January 5, 2021

RE: The Reserves at Corral Bluffs (Filing 5)
Section 31 T13S, R64W, 6th P.M.
Water Division 2, Water District 10
Upper Black Squirrel Creek Designated Basin

State Engineer's Office Opinion

THE RESERVE AT CORRAL BLUFFS FILING NO. 5

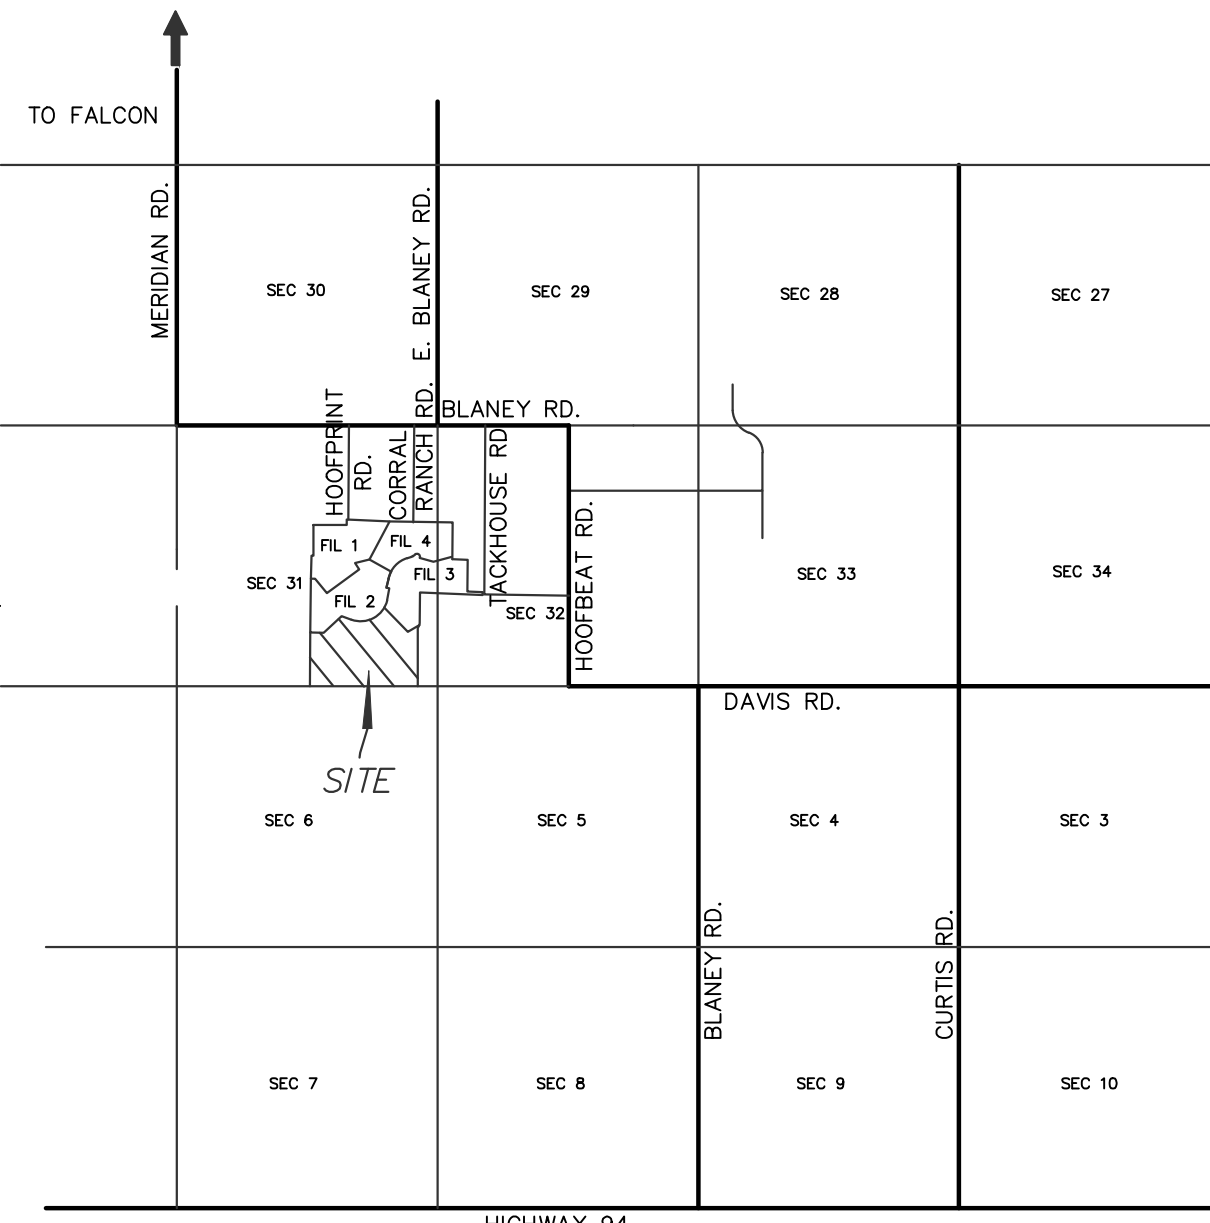
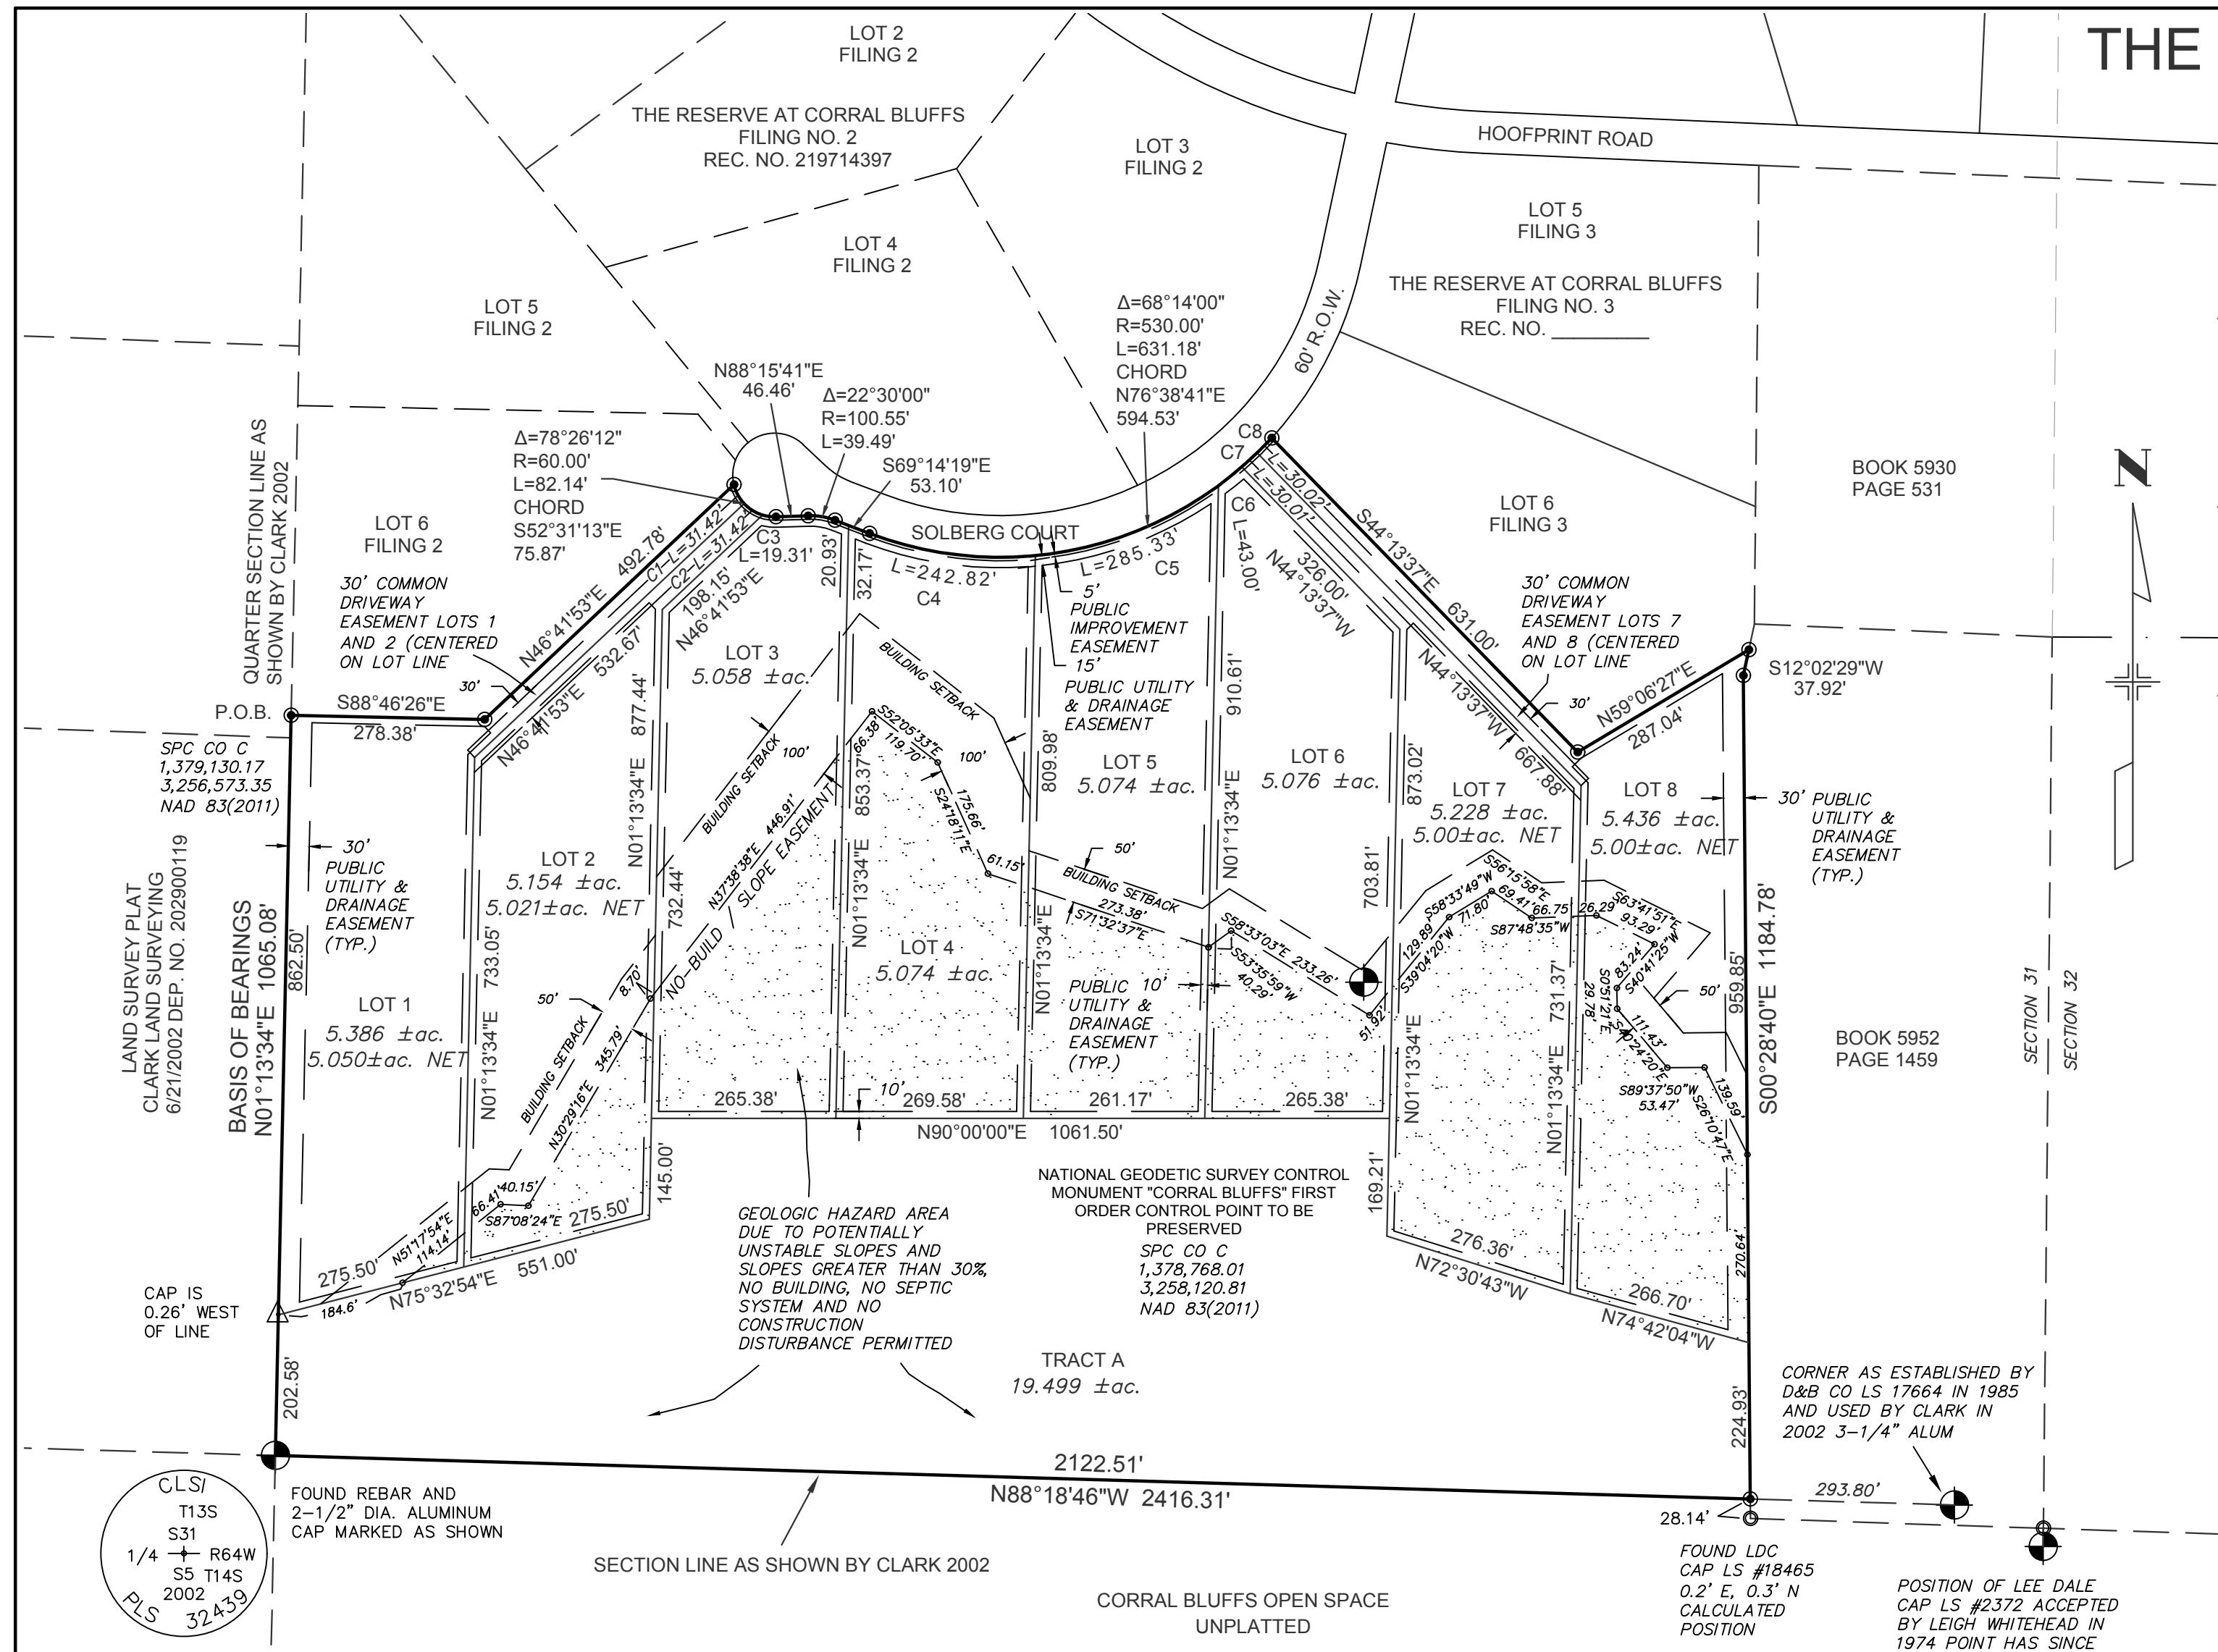
1. The developer must specify which lots will be required to seek Arapahoe aquifer wells (10 lots minimum for the entire Corral Bluffs development) and which lots can seek wells in either the Denver or Arapahoe aquifer (21 lots maximum for the entire Corral Bluffs development).
